Recommendation Report for Planning Permission for Works or Extension to a Dwelling

REF NO: BR/293/21/HH

LOCATION: 73 Nyewood Lane
Bognor Regis
PO21 2SD

PROPOSAL: Two storey side and rear extension, rebuilding of existing conservatory and demolition of existing garage.

1st Floor Plan

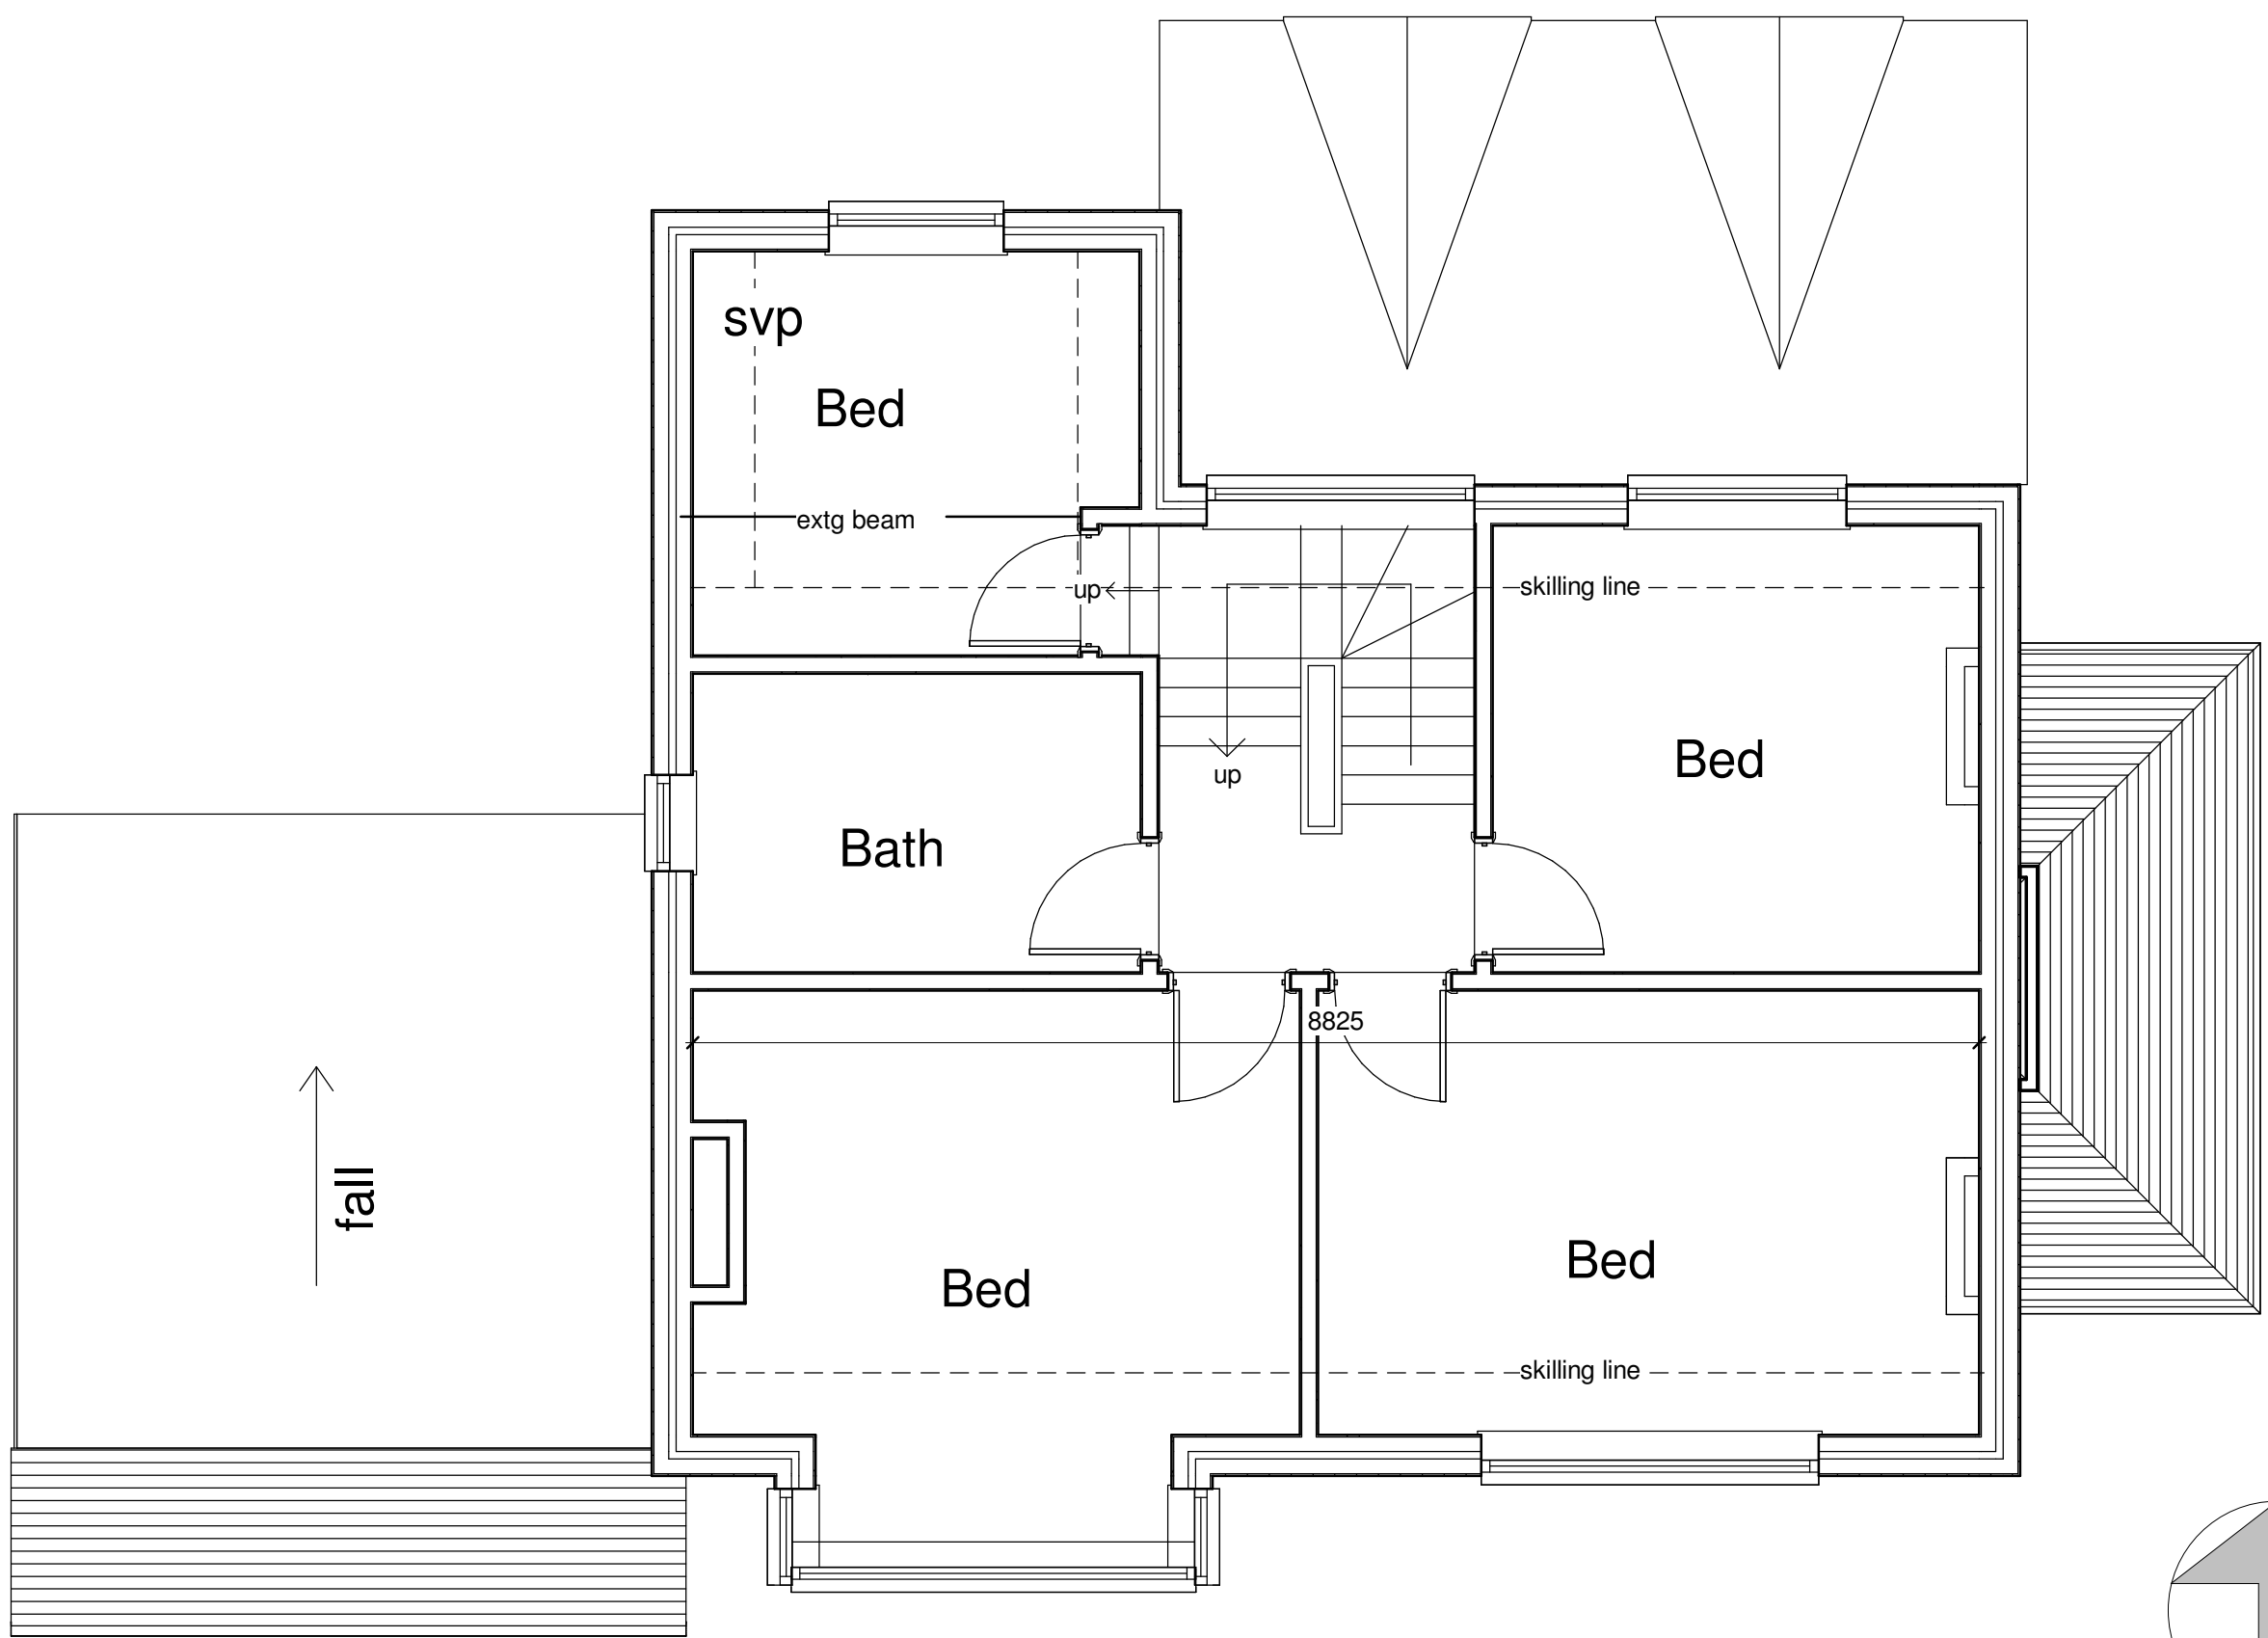
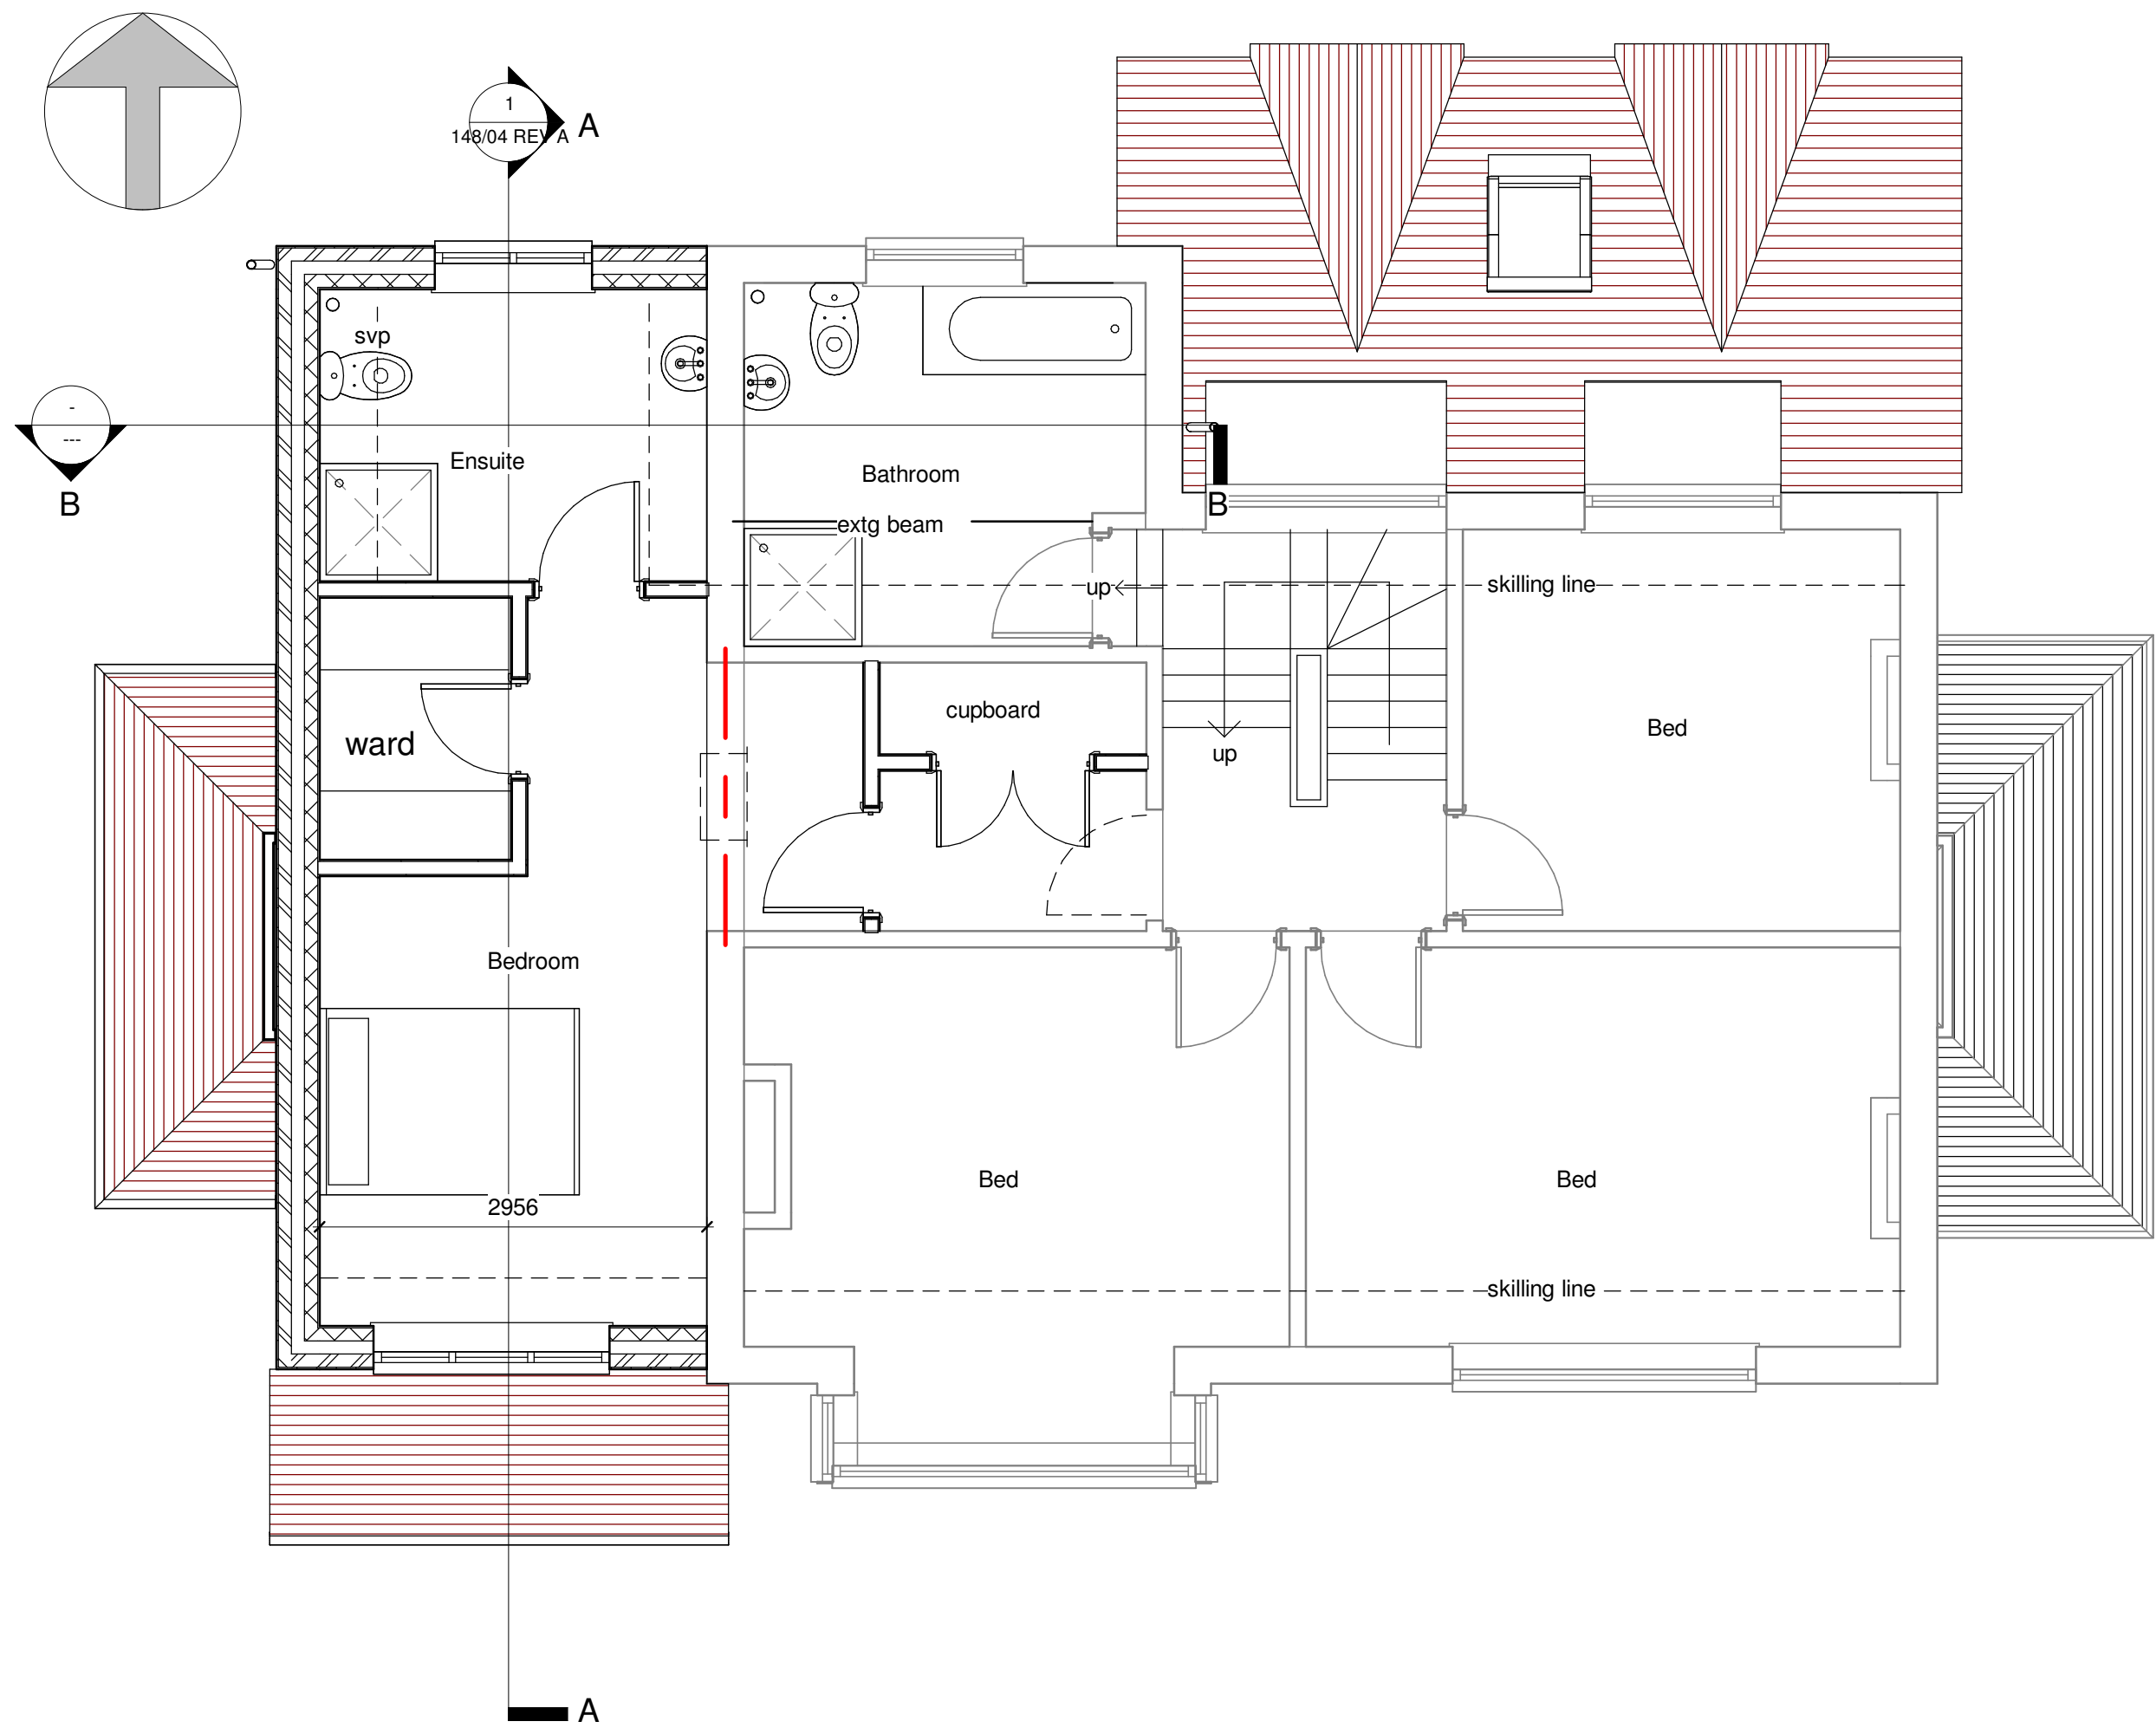
The side extension will have a width of 3.25m at two storey with a further 1.3m at single storey. The proposal will run along the full side elevation joining with an existing gable roof two storey to the rear. With the extension featuring a gable roof which extends from the host dwelling this therefore adds bulk to the property.

The extension will be visible from neighbour to the north at No.75. The extension will meet in line with the rear of the existing rear two storey projection and whilst the roof will be slightly higher its depth does not extend beyond the existing rear and therefore it is not considered to result in an increase in overbearing upon the windows to the rear /side of No.75.

There will be an additional window to the rear at first floor level which will serve a bathroom. Due to the separation and angle of views towards the north, it would not provide adverse overlooking towards No.75 or No.3. An additional front facing first floor window will overlook the street scene. There will be doors to the ground floor of the extension and the alteration of windows to doors to the conservatory will provide views over the garden of the property.
